Rezoning Transportation Analysis

Petition Number: #2021-198

General Location Identifier: Tax ID 18712322

Revision Log:

REZONING PETITION 2021-198

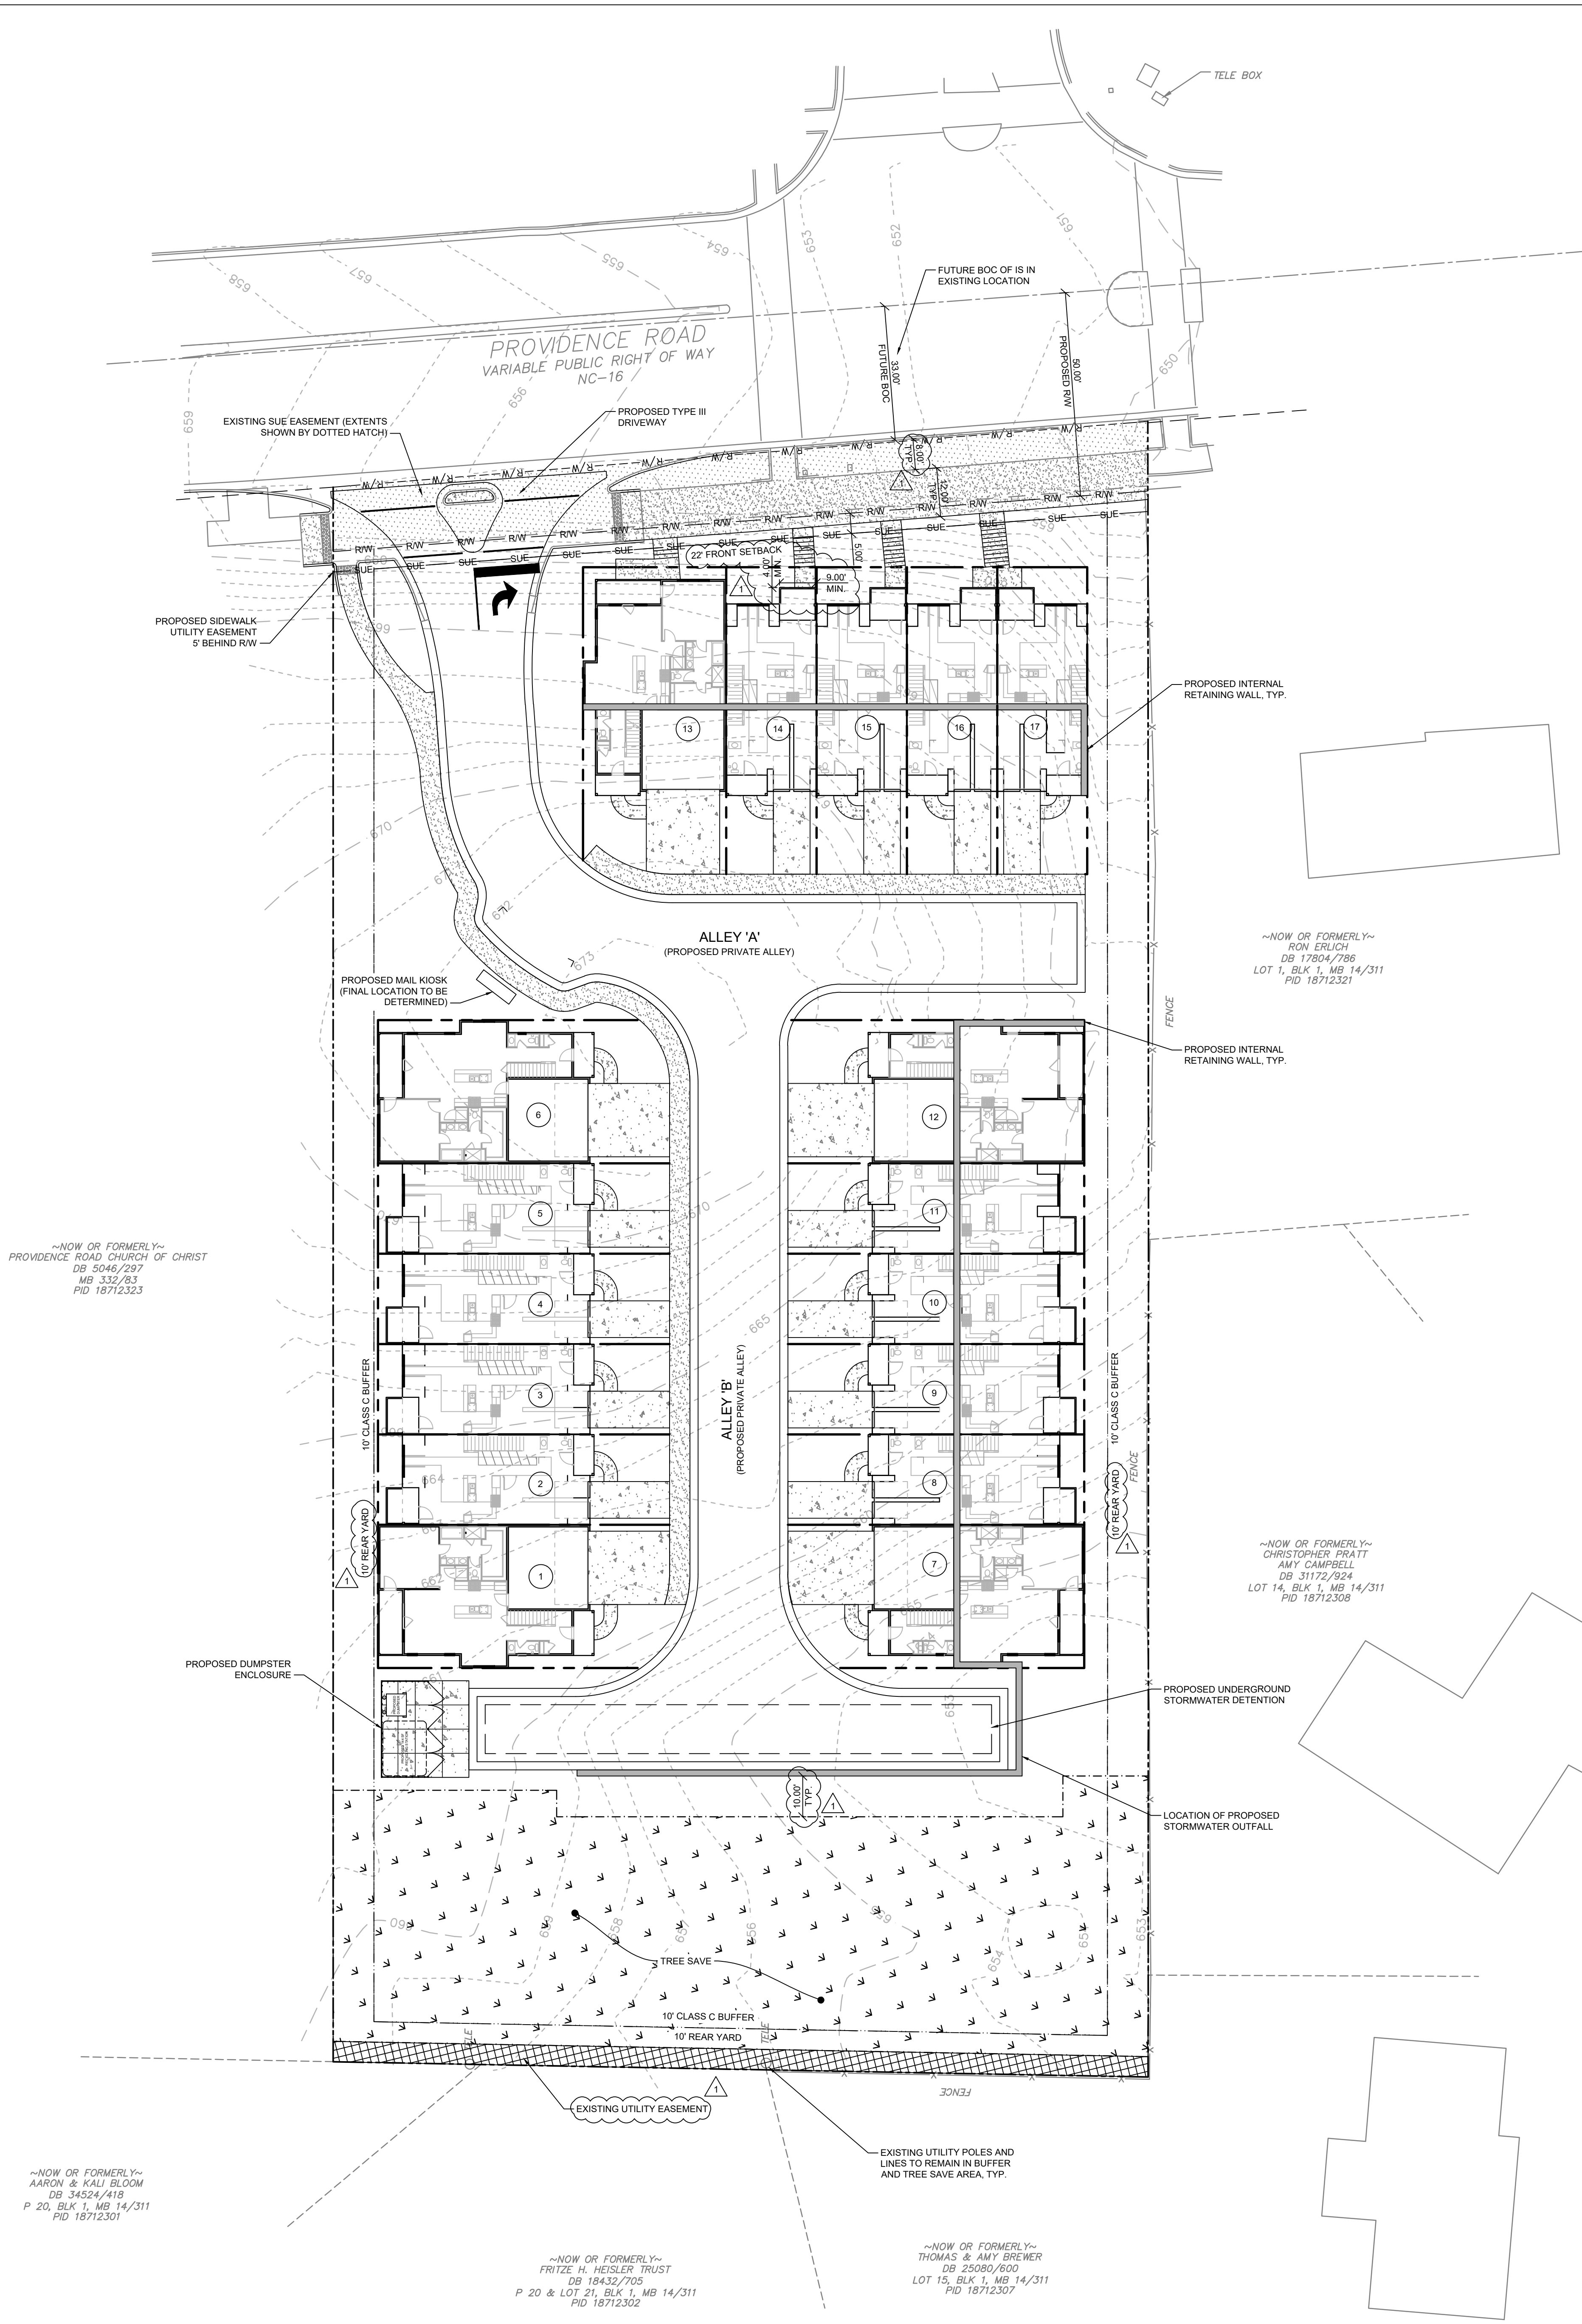
Clarifying comment 2-22-23: Per email exchange on 1-23-23, CDOT has informed the developer that the future back of curb is 33' from centerline. Site plan is currently showing 30' and suggesting the current curb and gutter is in the future location, this is incorrect. Adjust planting strip and 12' MUP accordingly.

Clarifying Comment 2-22-23: Site plan to include conditional note as well committing to an 8 foot sidewalk and 12' multi-use-path.

8. ~~New Comment Based on 11-04-22 site plan:~~ The relocated driveway now creates a conflict with access to building. Revise and update site plan so that ramp leading to driveway access does not conflict with access to building.
